**WELWYN HATFIELD BOROUGH COUNCIL
ASSISTANT DIRECTOR (PLANNING)**

DELEGATED APPLICATION

Application No: 6/2023/1124/FULL
Location: 2 Hill Rise Cuffley Potters Bar EN6 4EE
Proposal: Erection of a new dwelling following demolition of existing dwelling
Officer: Ms Elizabeth Mugova

Site Plan 1:200 Scale

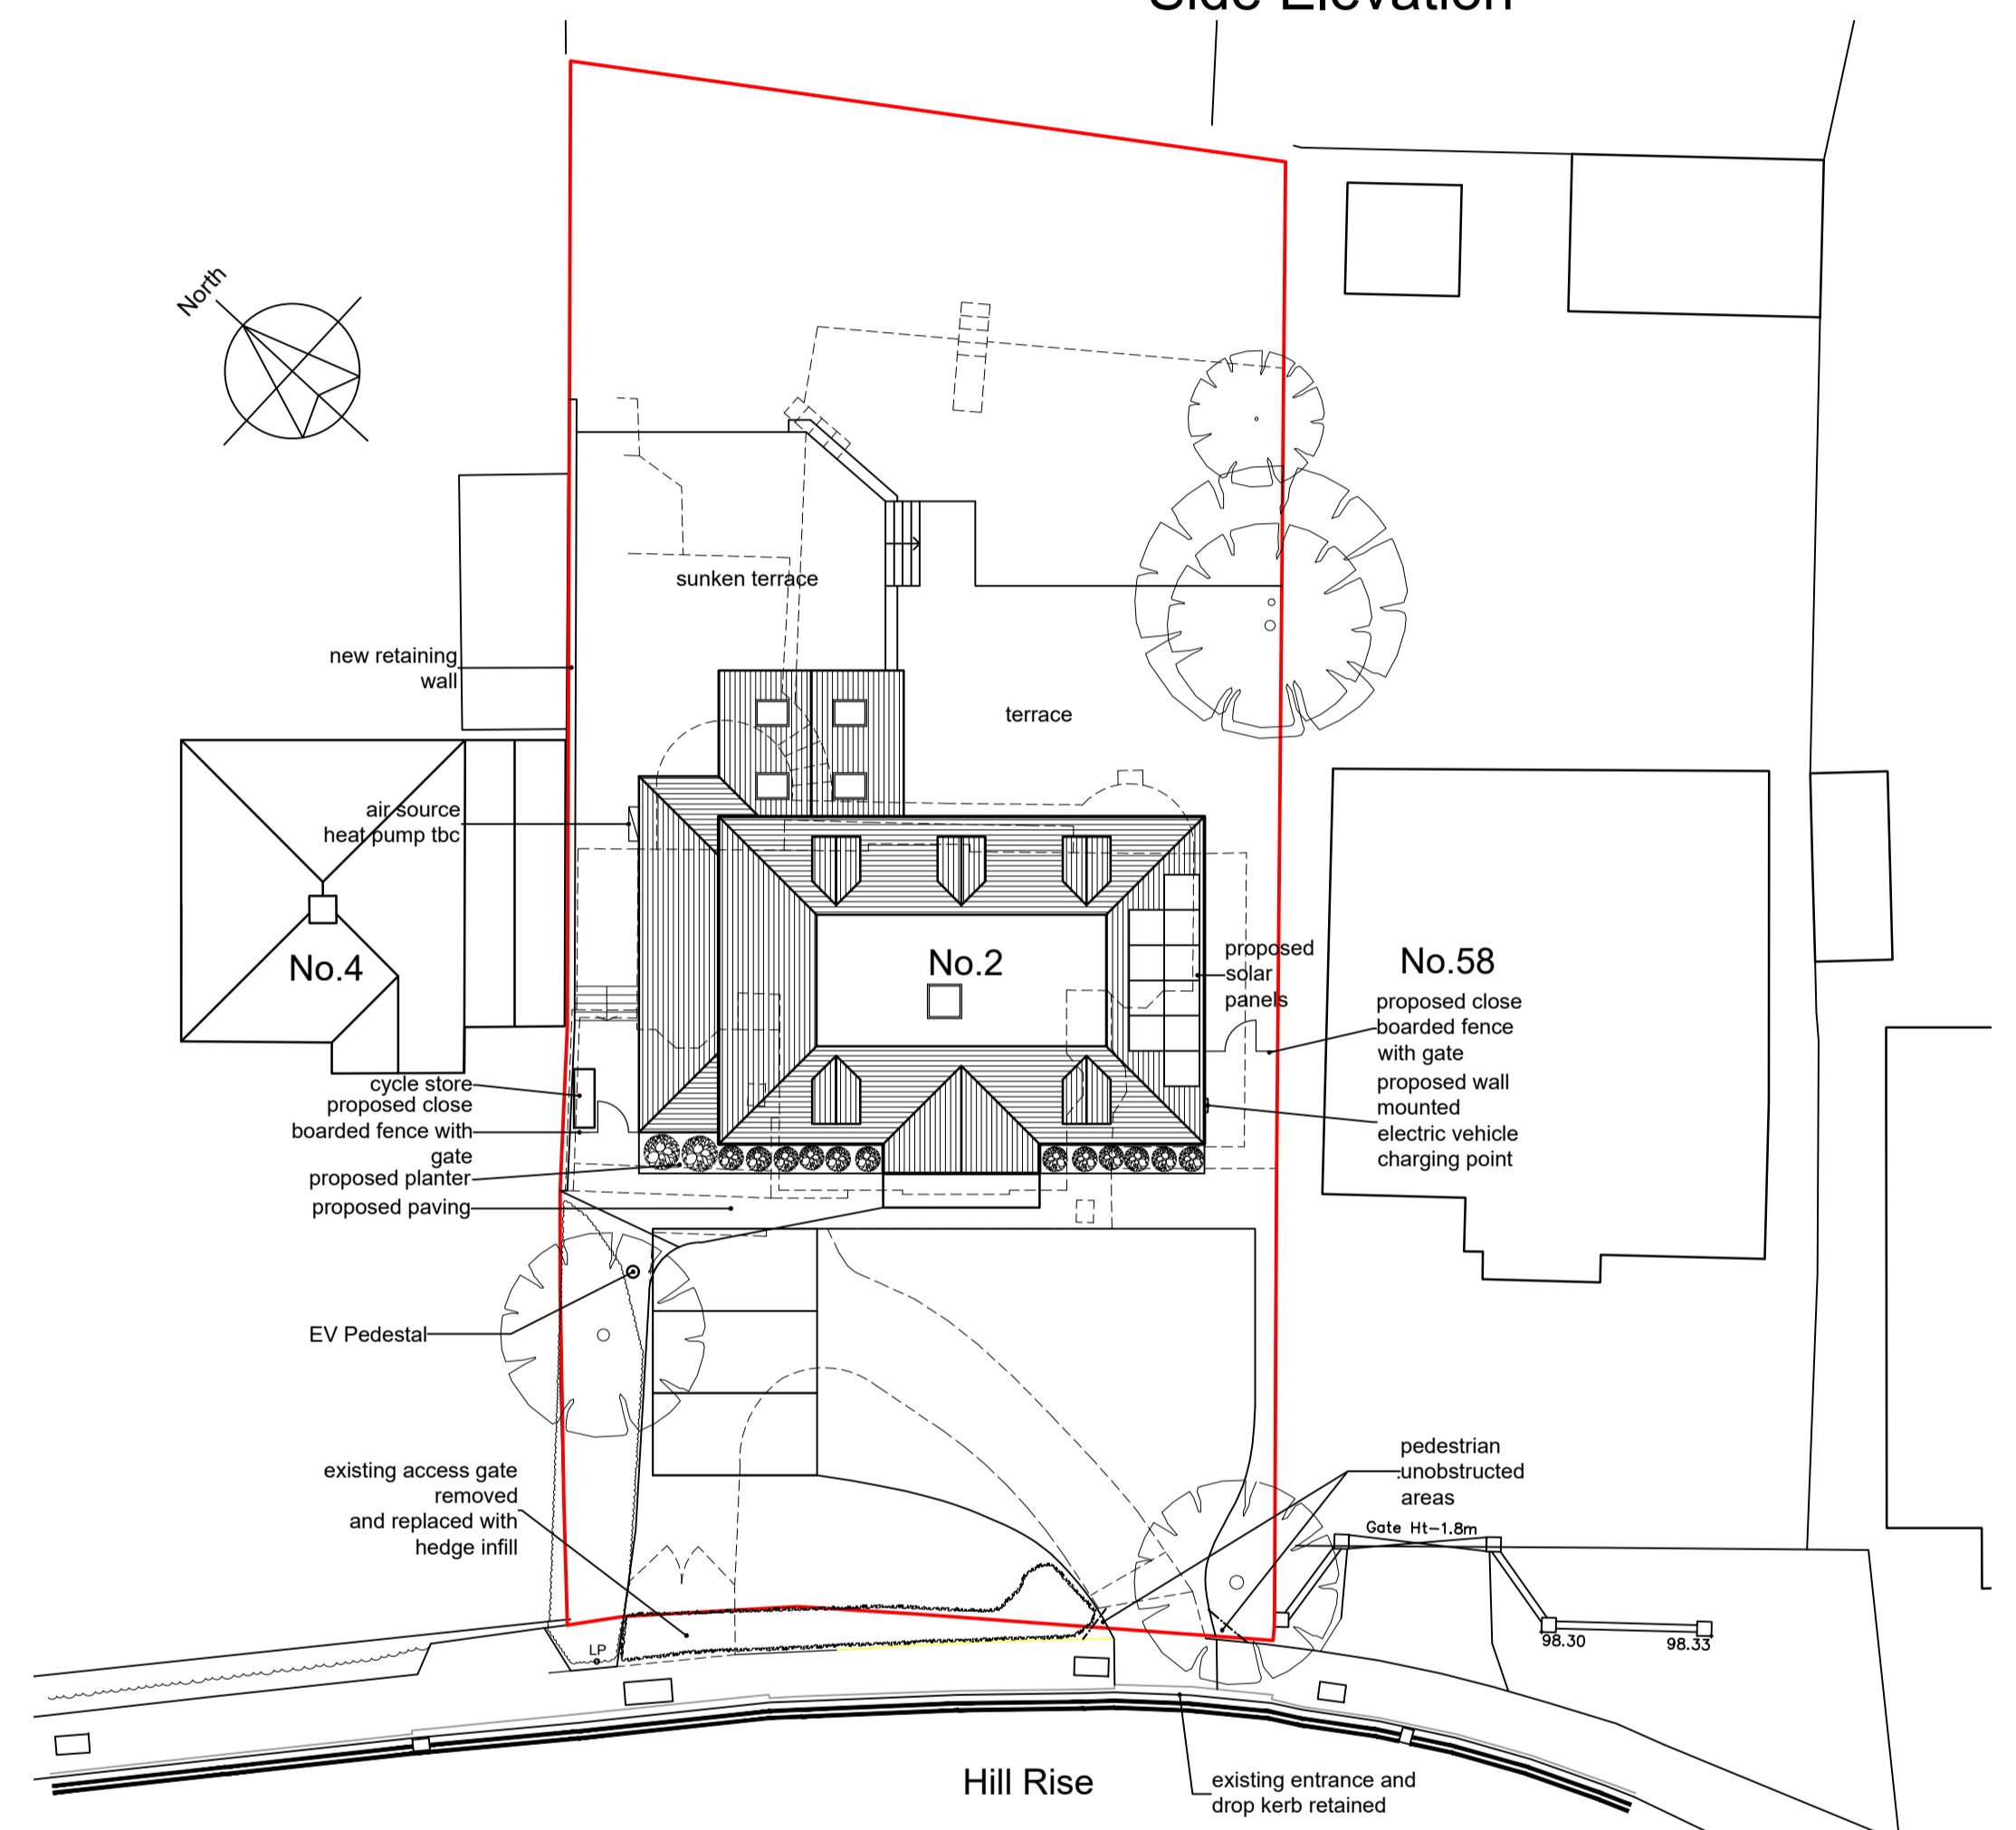
<p>to conditions. The amended drawings (20536-P001-H & 20536-P002-E) show that the existing northern vehicle access with a gate would be removed and replaced with hedge. The existing southern entrance would be retained and incorporate pedestrian visibility splays as shown on Drawing No 20536-P002-E. The proposal would therefore provide one access point onto the site and the visibility splays can be secured through a planning condition.</p> <p>Further to the above and subject to the suggested conditions, it is considered that the proposal would be in accordance with local and national policies.</p>
<p>Any other considerations</p>	<p><i>Sustainable design and construction</i></p> <p>The NPPF is clear that sustainable development is integral in determining planning applications. Policy SP10 of the Local Plan requires proposals to adopt sustainable design and construction principles through the design of buildings, materials and waste, water sensitive design, energy and climate change and landscape and biodiversity.</p> <p>In terms of energy and climate change, this includes the layout and design of the site and building to reflect the energy hierarchy to maximise opportunities to reduce carbon emissions; the use of renewable and low carbon energy infrastructure is used; and proposals are responsive to how the climate will change over their lifetime and minimise their contribution to the urban heat island effect.</p> <p>Further to this, Policy SADM13 of the Local Plan requires all newly constructed dwellings will be required to achieve an estimated water consumption of no more than 110 litres/person/day, with water reuse and recycling and rainwater harvesting incorporated wherever feasible to reduce demand on mains water supply. It is also recommended that new dwellings deliver some of their energy requirements from decentralised and renewable or low-carbon sources.</p> <p>To maximise energy conservation, the proposal includes an air source heat pump as indicated on drawing No. 205336-P001-H. However, specific details of the energy efficient measures have not been provided, it is therefore considered necessary and reasonable to attach a planning condition requiring details of a renewable energy scheme to be submitted to and approved in writing by the Local Planning Authority.</p> <p>The proposal does not include measures for long term water efficiency. It is considered appropriate to attach a condition requiring water efficient measures to be submitted to and approved in writing by the Local Planning Authority.</p> <p><i>Environmental Health</i></p> <p>The Council's Environmental Health team has been consulted and recommended a condition regarding noise from demolition/construction works and informatives.</p> <p>The recommended condition relates to 'noisy works' which is not precise and does not meet the condition tests. It is also a salient point that there are powers outside of Planning to enforce hours of construction works which are unreasonable/give rise to a statutory nuisance.</p>

5. The development hereby approved must not be occupied until the vehicle access with pedestrian visibility splays as shown on the approved plan (Proposed Site Plan No 20536-P002-E) has been constructed and laid out in accordance with the agreed details and shall thereafter be retained and maintained at all times.

6. The development hereby approved must not be occupied until the existing northern dropped kerb and access onto the site has been returned back to footway, with no means of access onto the site and shall thereafter be retained and maintained in this manner in perpetuity.

20536-P004-B

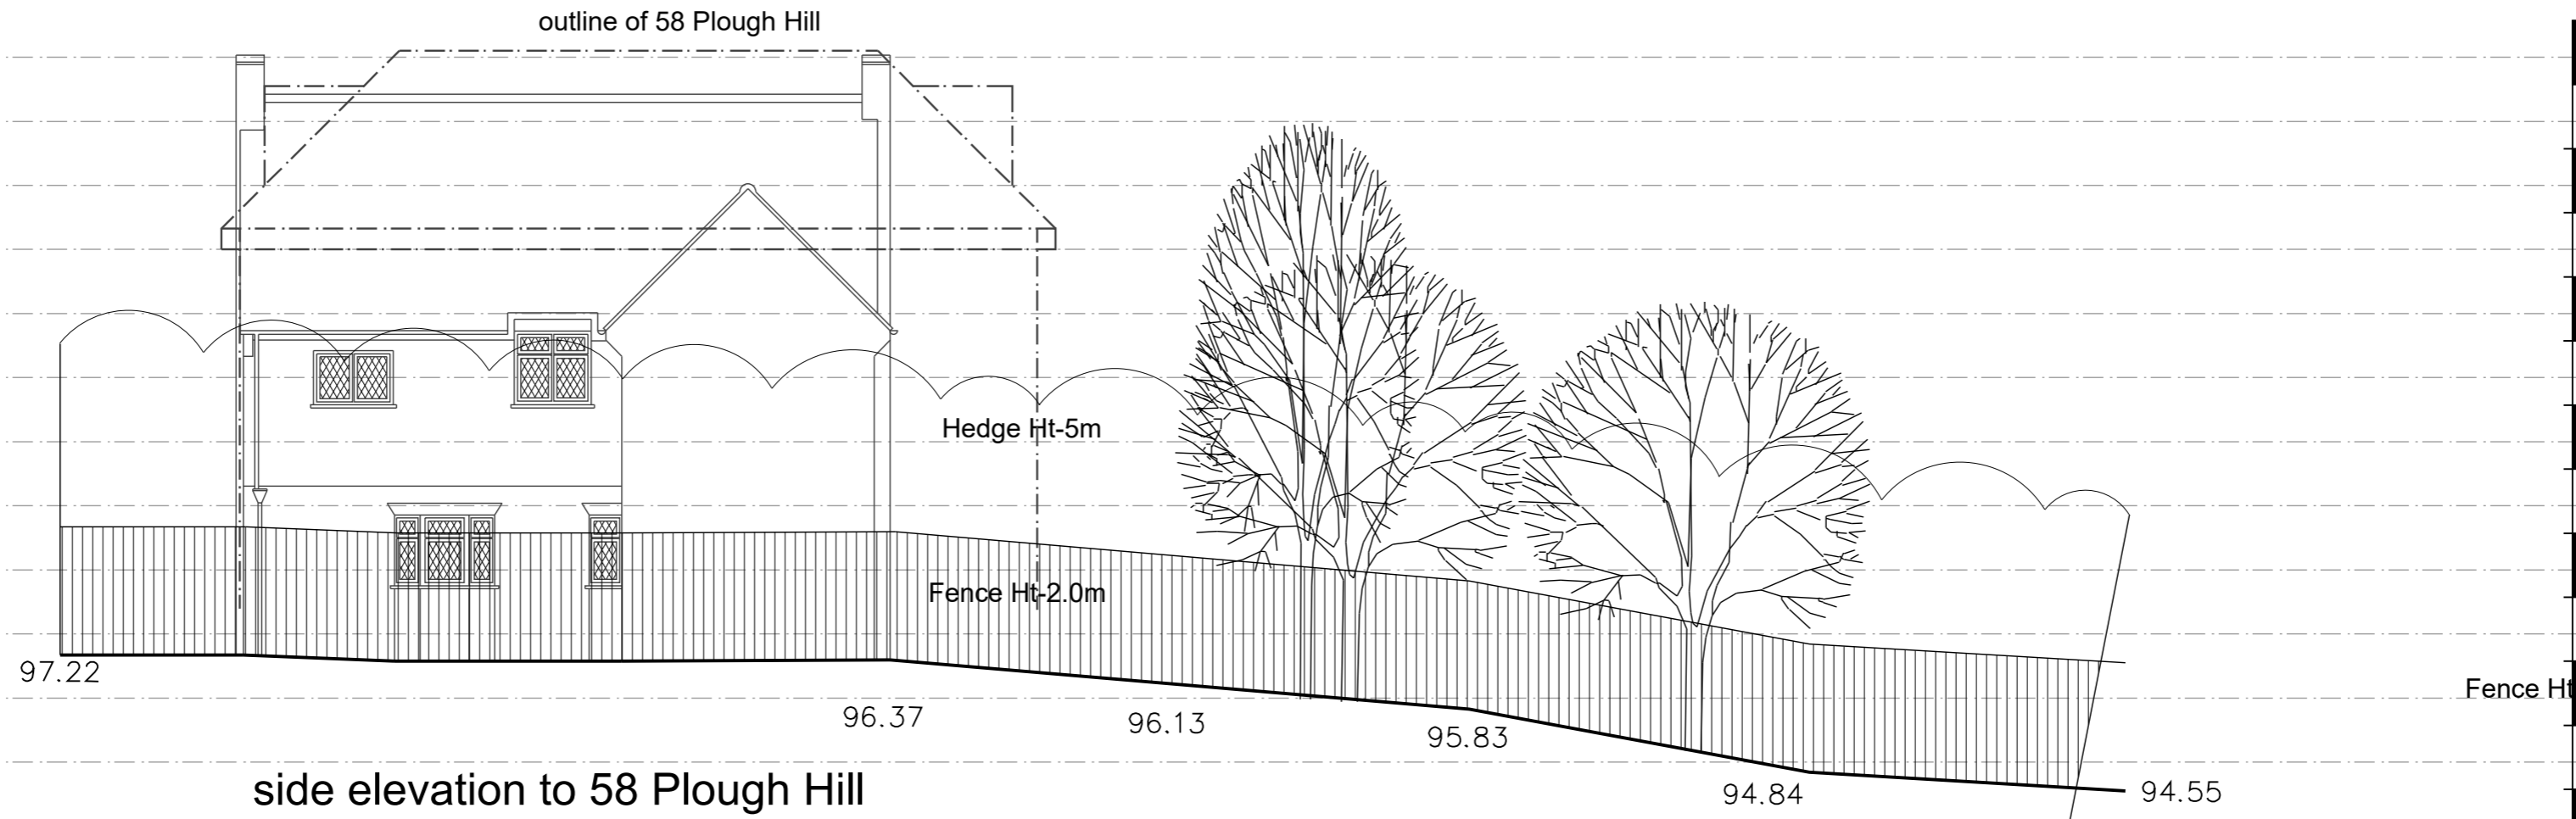
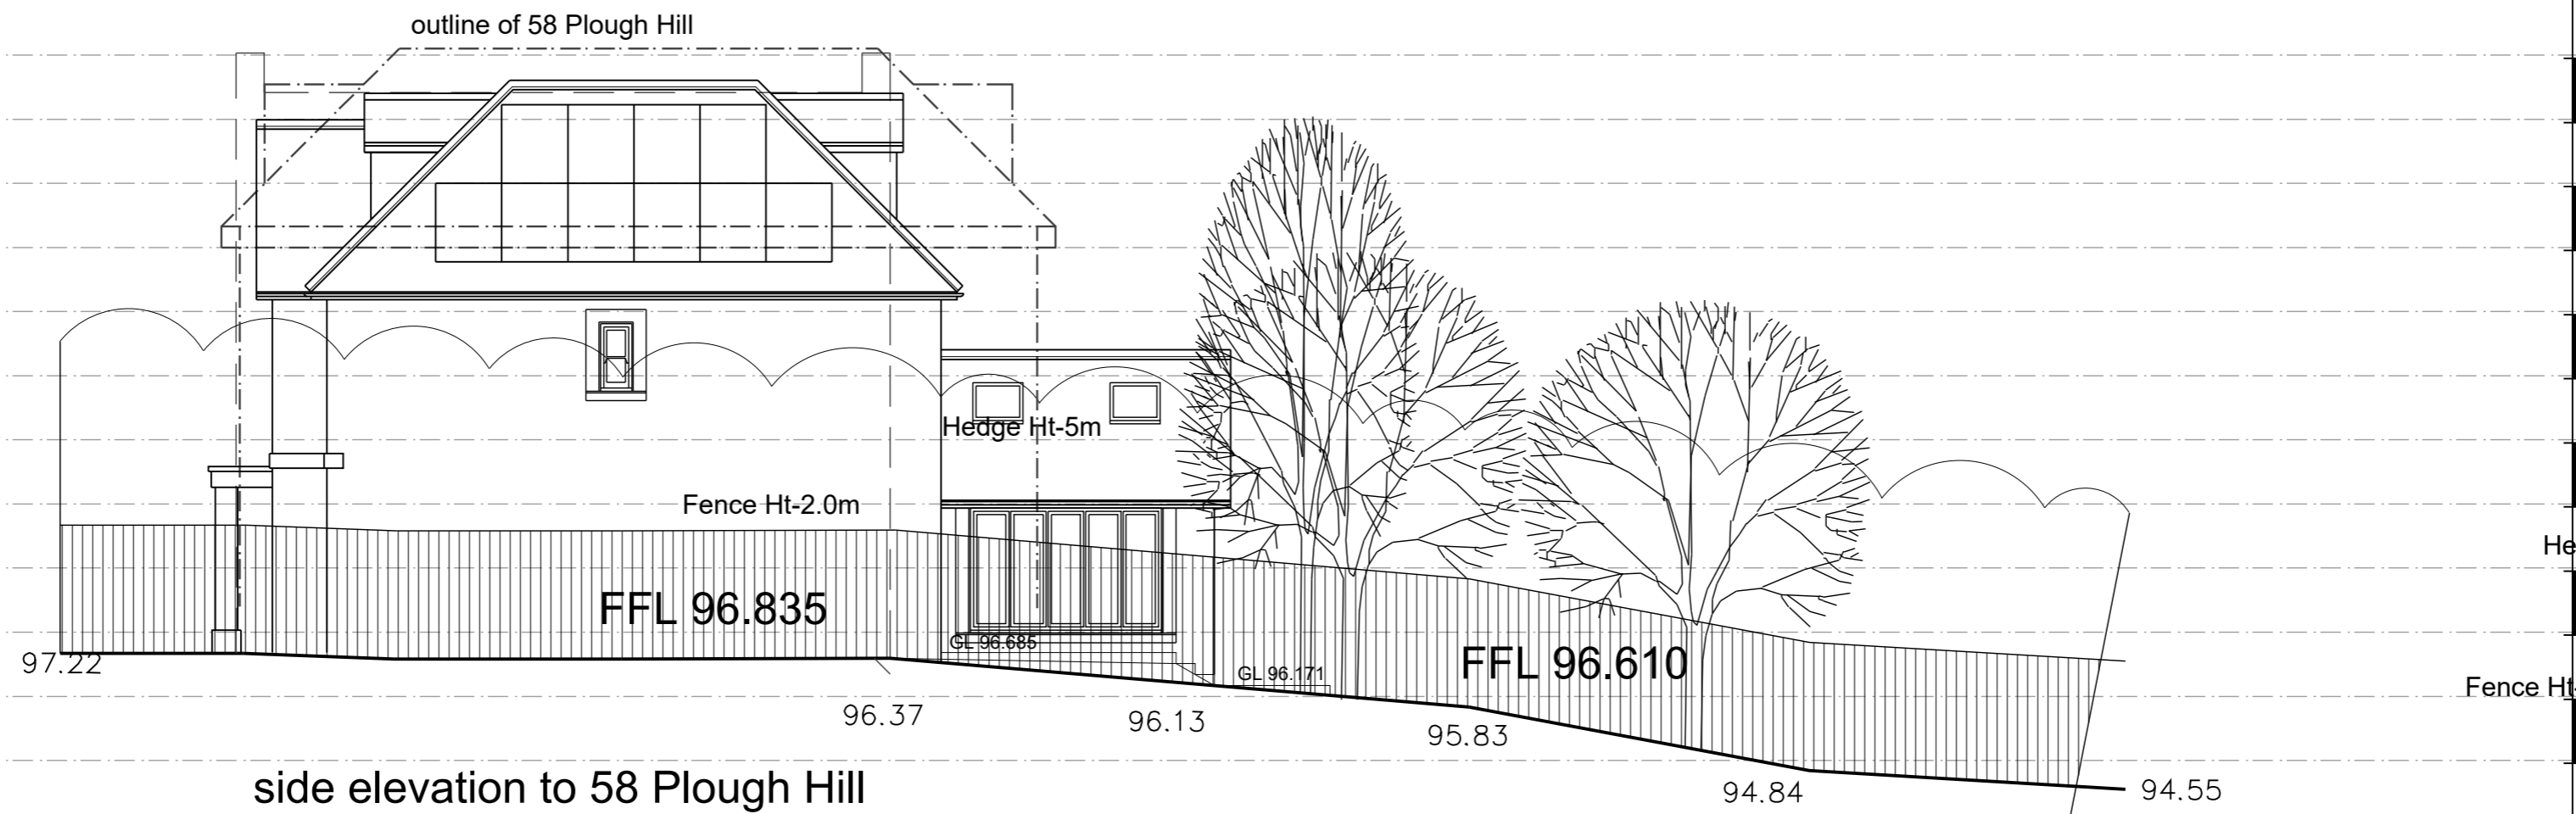
The first-floor side elevation window facing No 58 Plough Hill would serve a bathroom. This window is likely to be obscure glazed however, in order to maintain privacy of these neighbouring properties, a condition is attached to ensure that this flank window would be obscure glazed and fixed shut below 1.7 metres.

The surrounding land levels fall away towards the rear of the application site. The original proposal included a large rear terrace. However, during the course of the application, amendments to the application were submitted to include the reduction in size of the patio area and retention of existing ground levels for the sunken terrace and the patio. Given that the existing ground levels would be retained and the presence of hedges and fence which would provide screening it is considered that the rear terraces would not impact on the living conditions of neighbouring occupiers in terms of overlooking or loss of privacy.

10. The first-floor side elevation window [facing No 58 Plough Hill] of the building hereby approved must be obscure-glazed to a level equivalent to Pilkington Level 3 or above and non-opening unless the parts of the window which can be opened are more than 1.7 metres above the floor of the room in which the window is installed, and shall be retained in that form thereafter. Obscure glazing does not include applied film or one-way glass.
